**KIRKLEES METROPOLITAN COUNCIL
INVESTMENT & REGENERATION SERVICE**

**DELEGATED DECISION FOR APPLICATION FOR CERTIFICATE OF
LAWFUL DEVELOPMENT**

Reference no.: 2026/CL/92091/W

Site: 14, Lincroft Avenue, Dalton, Huddersfield, HD5
8DS

Client		Mr Smith	
Job		14 Lincroft Avenue Huddersfield	
Title		Existing Side Elevations	
Drawn By	RK	Date	July 2026
Eng. Check		Scale	1: 50
Tech. Check			
Drawing No.		Rev.	
2026 / 530 / 03

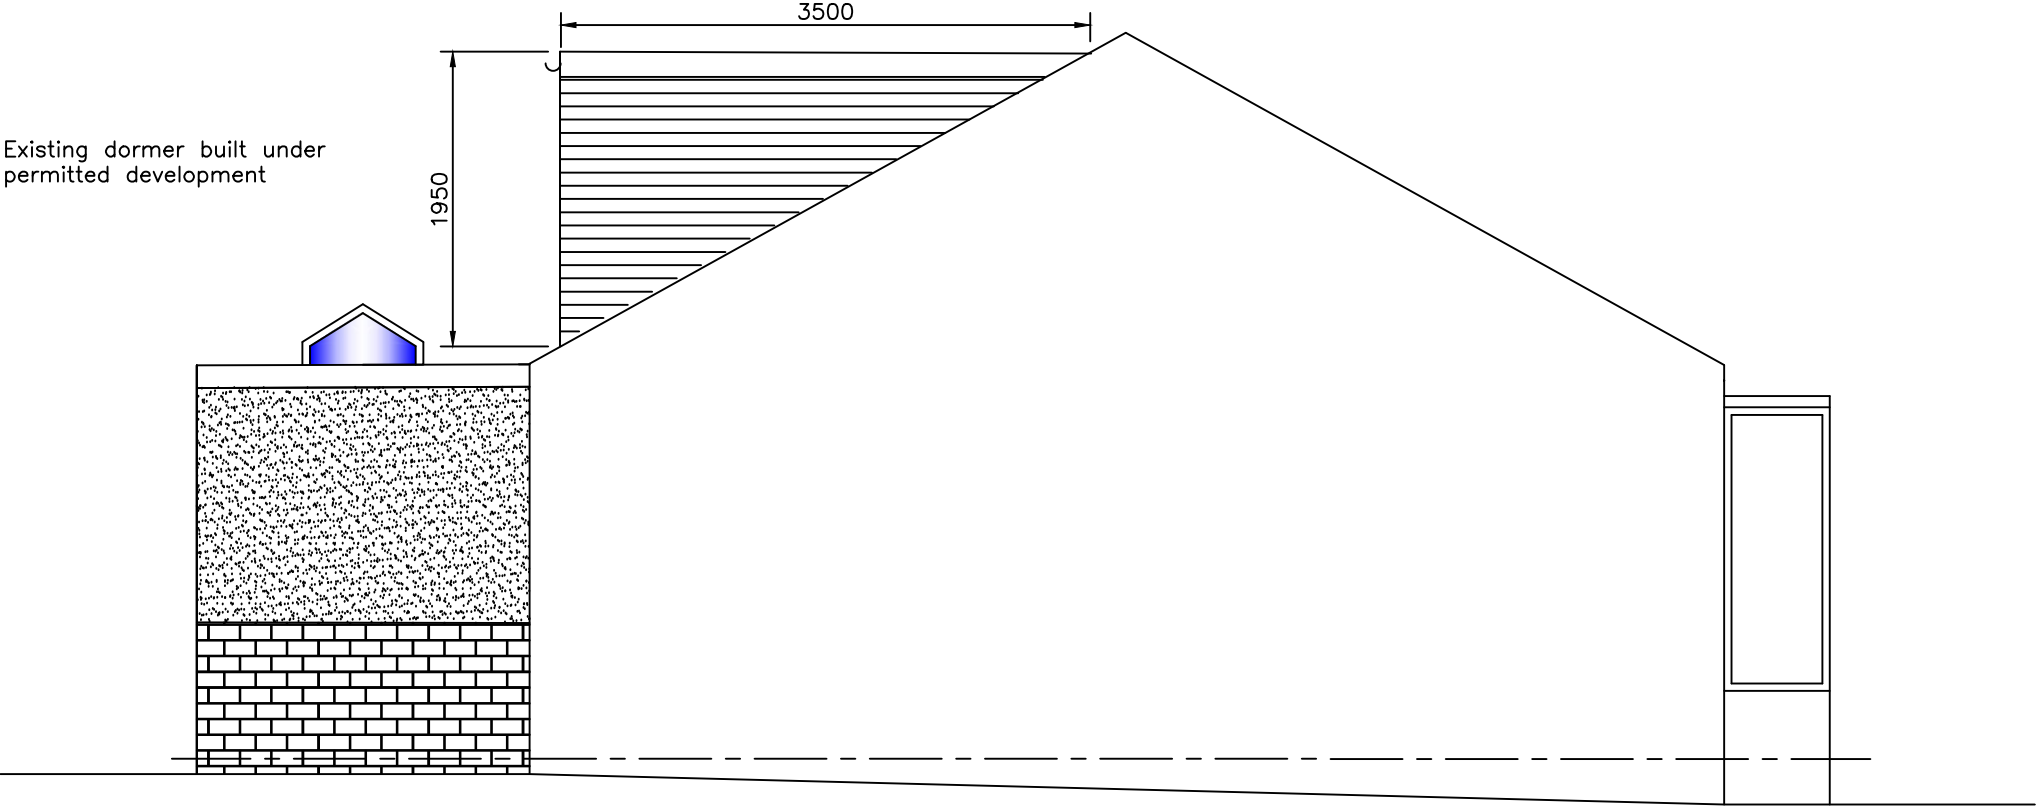
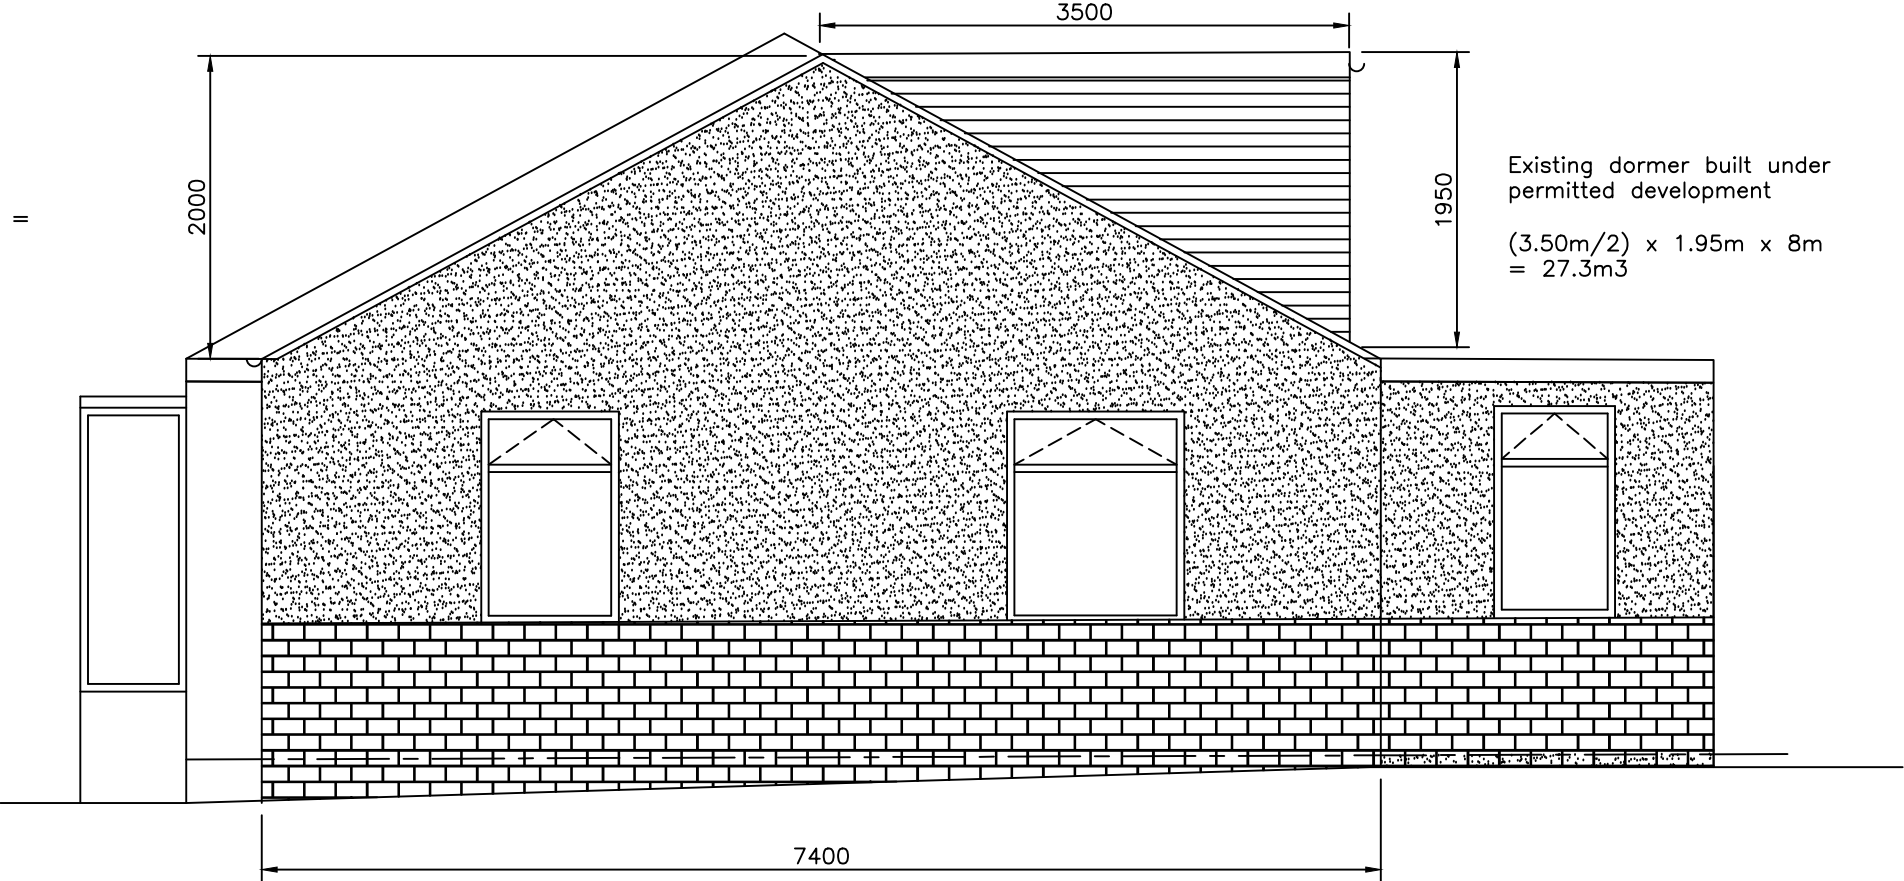
The submitted plans are annotated with the cubic volume of the side extension roof form. The plans state that the dimensions of the roof form are 7.4 metres x 2 metres x 3 metres. This would give a total roof volume for the side extension roof form as 22.2 cubic metres.

Comment: *The details contained within the submission include annotations on plan of the roof form of the side extension which is also additional roof space to be calculated as additional roof space. The dimensions of the side extension roof are 3m x 7.5m x 2m /2 which equate to 22.5m³. Therefore, when calculated with the dormer which has an increase of 27.3m³, this equates to 49.5m³ which is under the 50m³ threshold.*
